Report of the Head of Planning & Enforcement Services

Address 99 CROMWELL ROAD HAYES

Development: Conversion of roof space to habitable use to include a rear dormer, 2 front rooflights and conversion of roof from hip to gable end (Application for a Certificate of Lawful Development for a Proposed Development)

LBH Ref Nos: 5530/APP/2011/931

PROPOSED 2nd/FLR/PLAN (1:100). THIS IS RIGHT LOFT PLAN.

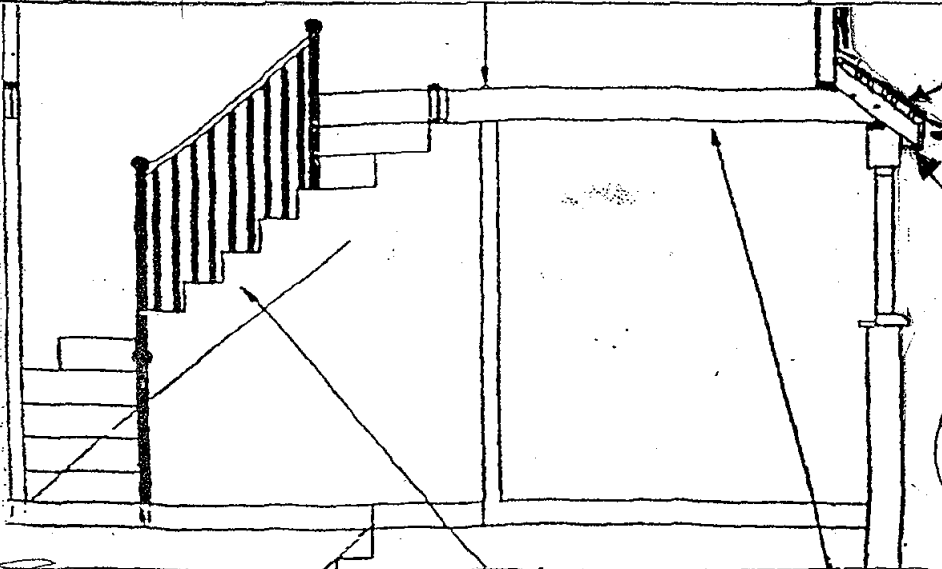
It is also noted that the drawings submitted in support of the application, are inconsistent and in particular do not clearly demonstrate whether the proposed dormer would be set in an appropriate distance from the eaves or that any side facing windows would be obscure glazed. The drawings do not reflect the development which has been substantially completed on site.

Is the enlargement/dormer set in 20cm (200mm) from the roof margins?
NO - Part of the development is a hip to gable, however the rear dormer does not demonstrate the necessary set in from the eaves and the plans are inconsistent in this respect.

Are any side facing windows obscurely glazed?
No - The plans are inconsistent with the second floor plan showing a new window which is not indicated to be obscure glazed, but the elevations showing no new window.
